Project No. 21101

**Re: PA22-024- Marysville 44th PRD – Technical Review 3  
7315 / 7417 44th St NE – APN(s) 30053500303700 / 30053500303600**

This letter is provided as response to comments dated May 16, 2023. Each item has been carefully reviewed and considered and the following is a summary of how each item was addressed.

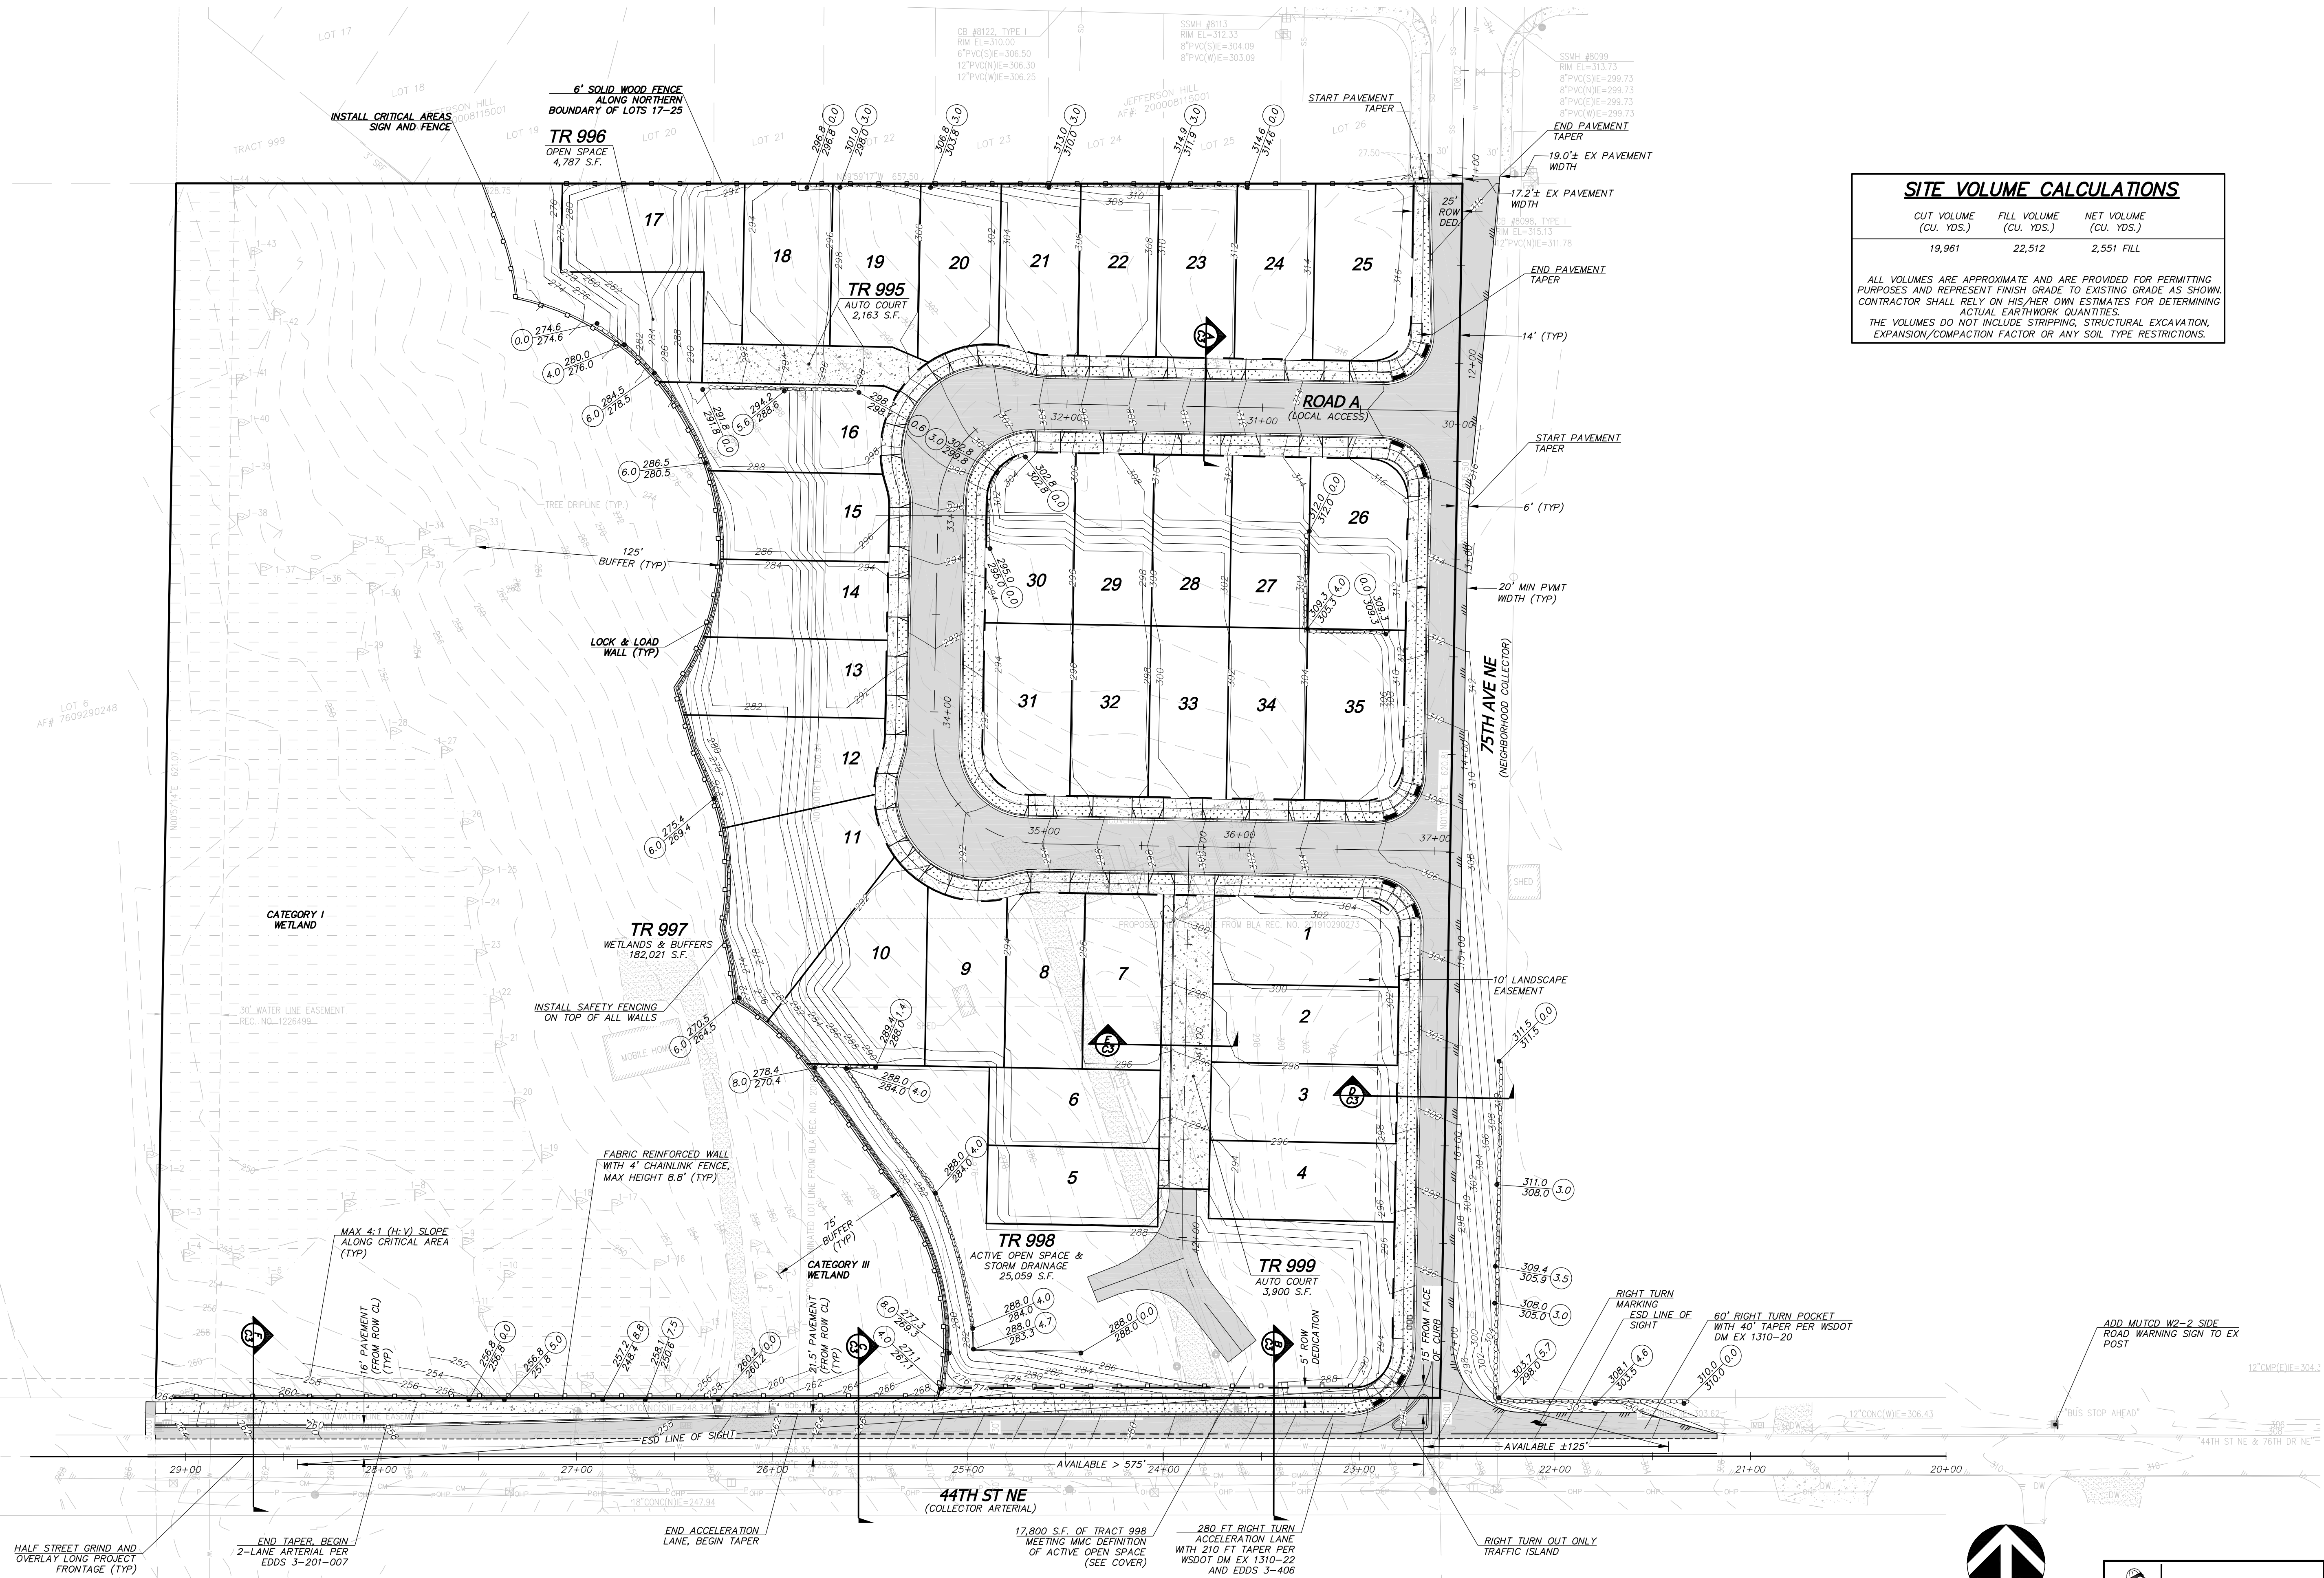
- a. The westbound right-turn deceleration lane on 44th St NE shall be consistent with WSDOT's Design Manual (DM) Exhibit 1310-21 to mitigate sight-distance. The multiplier for downgrade shall also be evaluated.

- b. The westbound acceleration lane on 44th St NE west of 75th Ave NE shall be consistent with WSDOT's DM Exhibit 1310-22. The northern 44th St NE curb line shall be shifted south as feasible to create a planter strip up to the width shown in EDDS Plan 3-201-007.
  - i. The design speed for the southbound right-turn curve may be used to interpolate this lane length. The multiplier for downgrade shall also be evaluated. The taper rate in EDDS 3-406 should be used instead of 300'.

***Per consultation from Mark Jacobs, PE, PTOE, a right turn pocket, per WSDOT Exhibit 1310-20, is more appropriate for the situation. The existing design has been updated to meet the dimensional requirements of Ex 1310-20, right turn pocket, with a 60' pocket and***

**a 40' taper. A W2-2 side road warning sign is also proposed east of the Site to warn approaching vehicles of the intersection. See attached correspondence and guidance from Jake Traffic Engineering, Inc.**

**The westbound acceleration lane has been updated to the design criteria of WSDOT Exhibit 1310-22. The intersection of 44<sup>th</sup> ST NE and 75<sup>th</sup> Ave NE will be stop controlled so a lane length of 280 ft will be provided. Since the design speed is 35 mph no adjustment multiplier for downgrade is required. The taper length was calculated per EDDS 3-406 at 209', for design a value of 210' will be used. The required acceleration lane and taper take up the majority of the frontage. There will be a portion where construction of a planter strip will not be feasible due to the required width for the acceleration lane and the critical area. At the far west end of the improvements the designer has elected to maintain the sidewalk position near the edge of the ROW and widen the planter strip to allow the PRV vaults and other transmission main infrastructure to be located within the planter strip and not within the sidewalk to the maximum extent feasible.**
